April 30, 2015
15098

425 Allen Avenue Review Comment Response

We received the review comments you sent to Nick Estes of EC Builders regarding the Estes Single Family residence at 425 Allen Avenue (CBL 401-a-001901), with Project ID: 2015-00338, dated April 29th. I'll address your comments by bullet items from your letter.

STONE DRIP EDGE
NOT TO SCALE

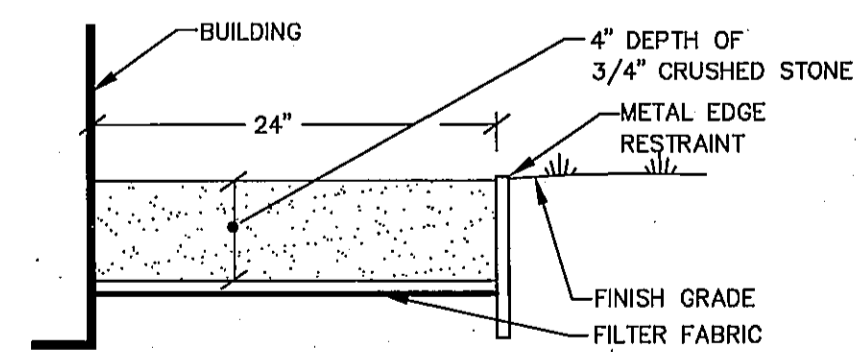
- *Please revise the grading plan to include stone drip edge around the foundation perimeter so that it is clear that neighboring properties will not be negatively impacted by stormwater surface drainage due to the increase in impervious surface, ie the roof drainage. **Stone drip edge has been added to the grading utility plan as well as a detail on the detail sheet***

**SITE PLAN**  
 OF:  
**LOT 2**  
 419 ALLEN AVENUE  
 PORTLAND, MAINE  
 FOR:  
**ESTES CUSTOM BUILDERS**  
 733 ROOSEVELT TRAIL  
 WINDHAM, MAINE 04062

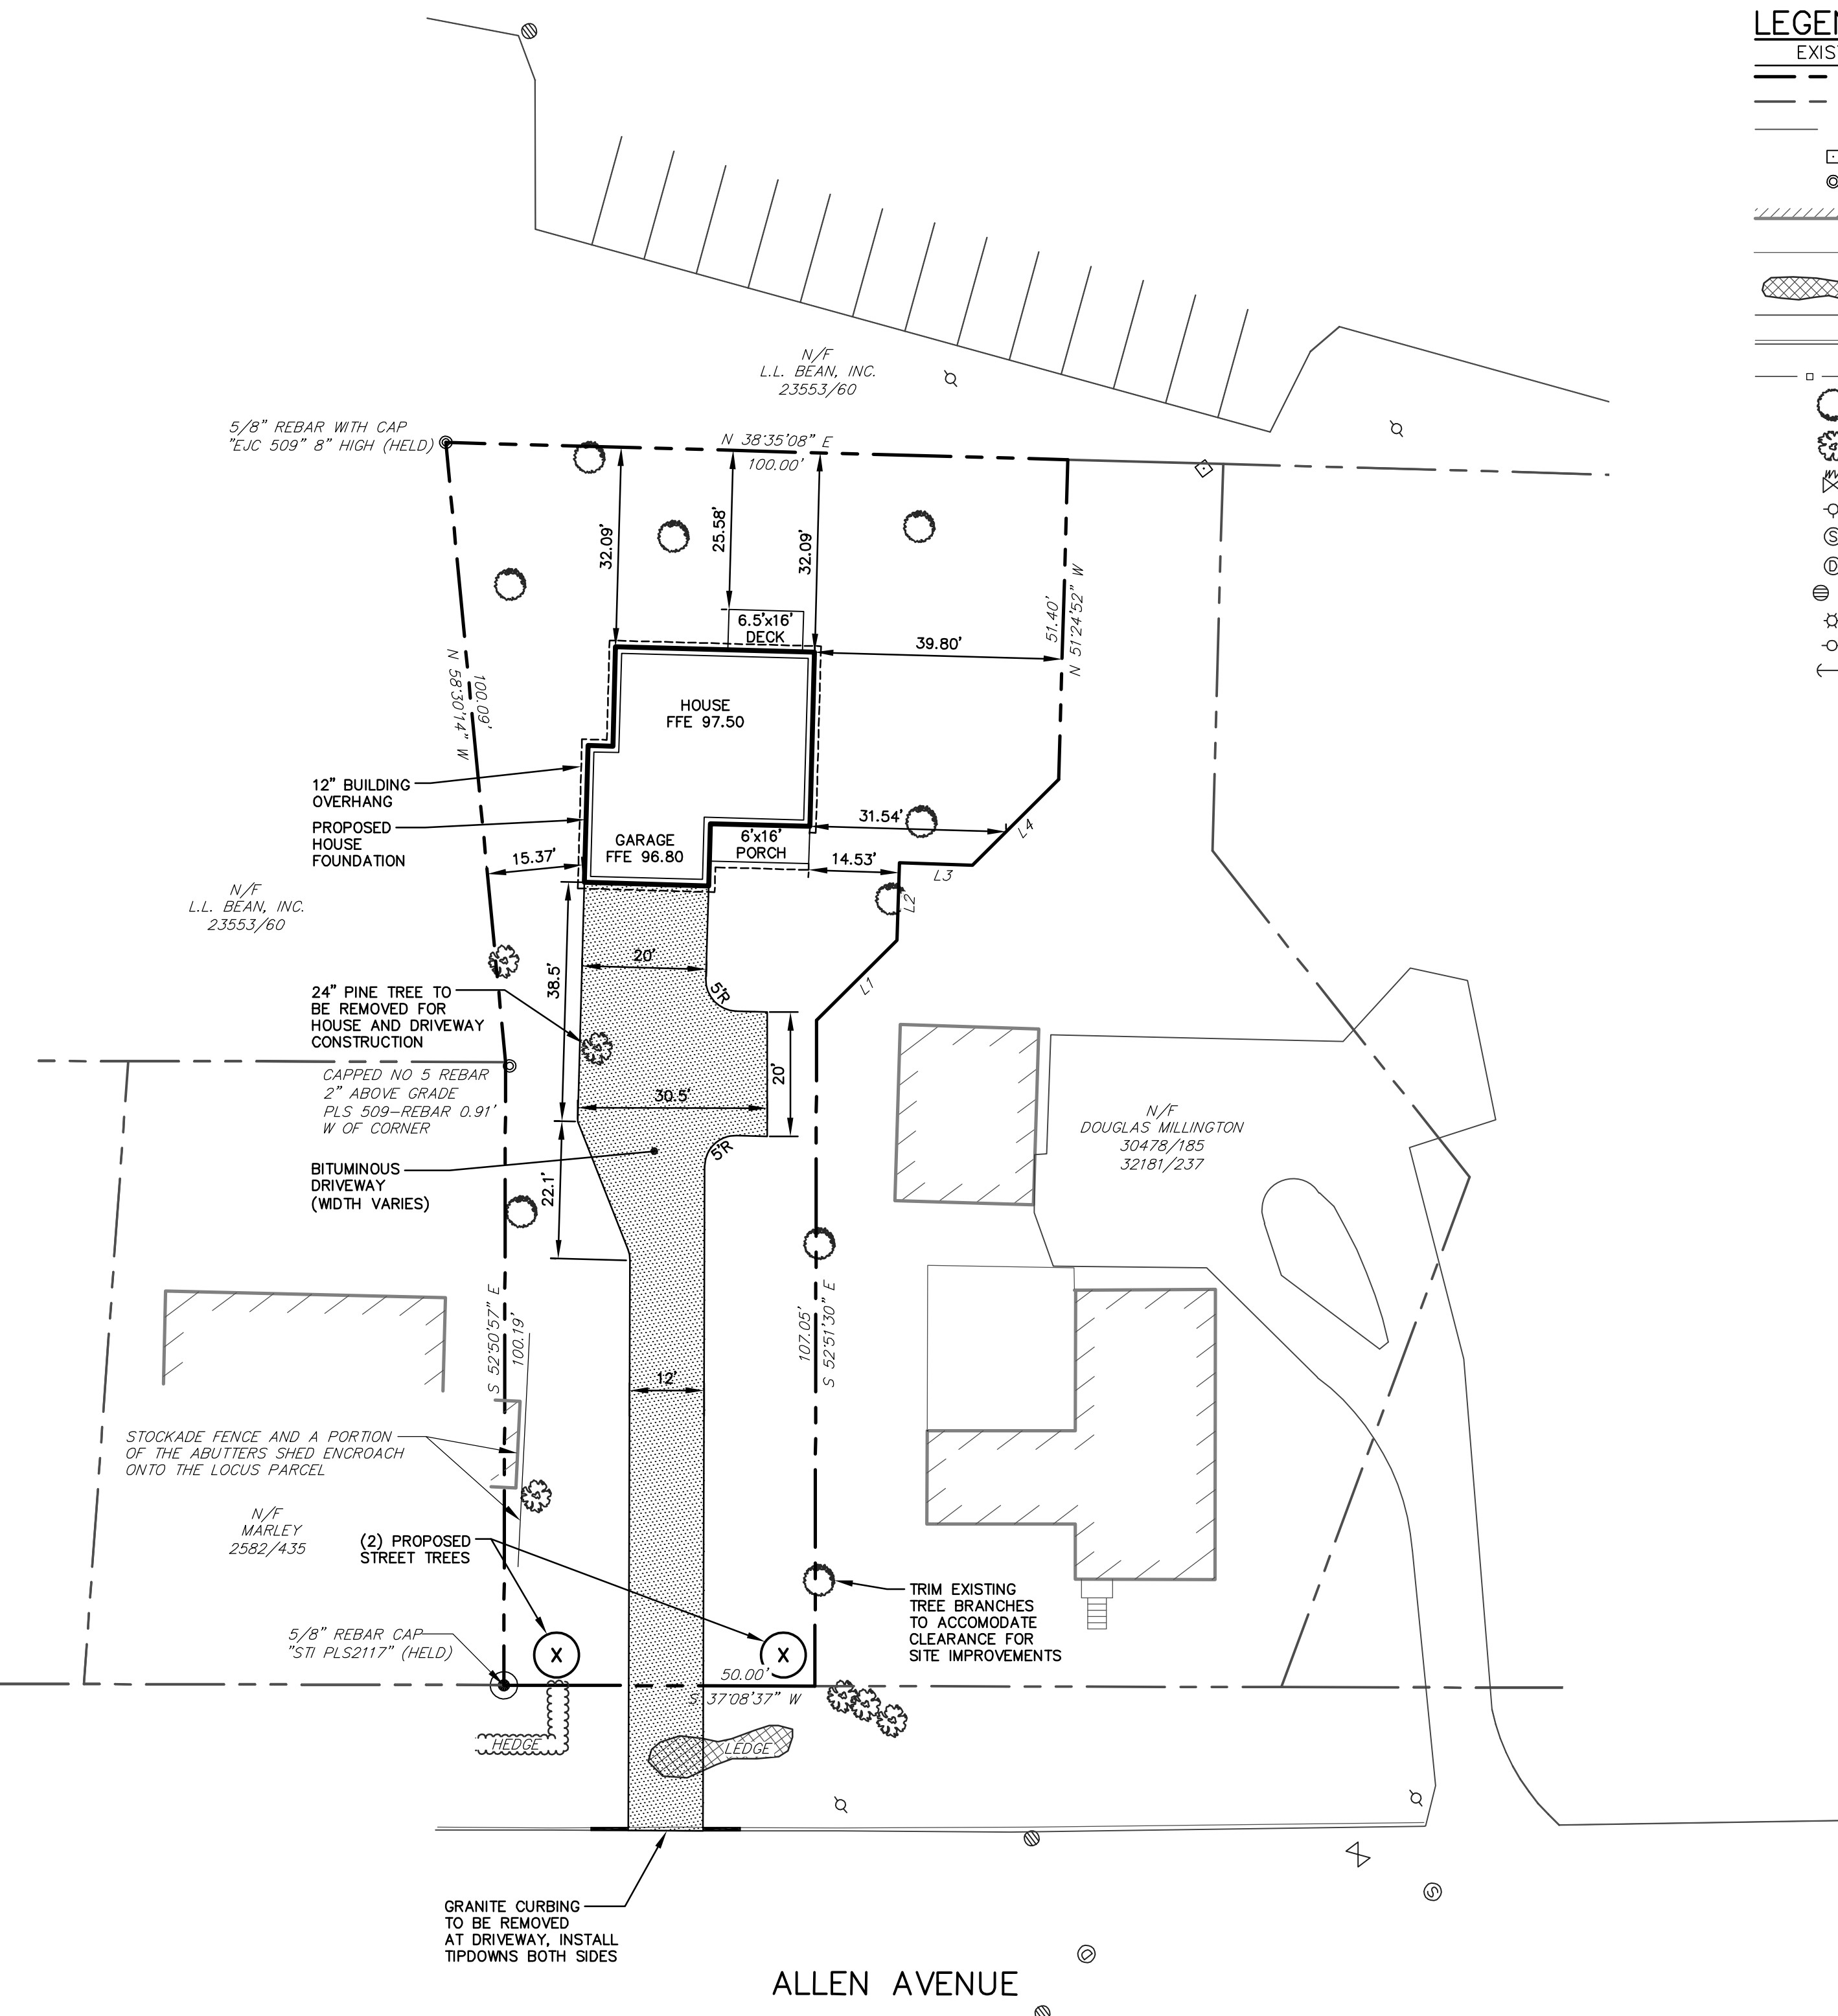
- *Flood Zone statement, where applicable, based on FEMA, FIRM Flood Insurance Rate Maps. **See Note 9 on the Site Plan.***
- *Property Corners: Location and descriptions of all property corners set or found, proposed to be set, and all granite survey monuments set. Where no property markers exist, the City of Portland requires that the property markers be installed, and that a licensed surveyor set and confirm proposed building locations on site prior to the issuance of a building permit. **Existing monumentation was previously labeled on the Site Plan. Proposed rebars are shown on the Site Plan now and will be set when building layout is performed.***

- *City Vertical Datum: It shall be stated on all plans that the City of Portland established vertical datum of NGVD 1929 is used or manhole rim elevation data is used for all information shown on the plan. **Datum information was listed in note 7 on the site plan.***

- *All plans shall state the Official City of Portland Benchmark used as supplied by the Department of Public Services .Engineering Division Archivist. **Benchmark information was added to note 7 on the site plan.***

- *Street Status: The Status of the street shall be show11; IE Accepted City Street, Continued Paper Street, Discontinued City Street, Vacated Paper Street, or new Proposed Street as per the project submission. **Allen Avenue has been labeled (Accepted on the Site Plan)***

- *Please add the ground floor areas to the site plan. **Added note 15 to the site plan listing requested areas.***
- *Please add the soil type to the site plan. **Added as note 16 on the Site Plan***
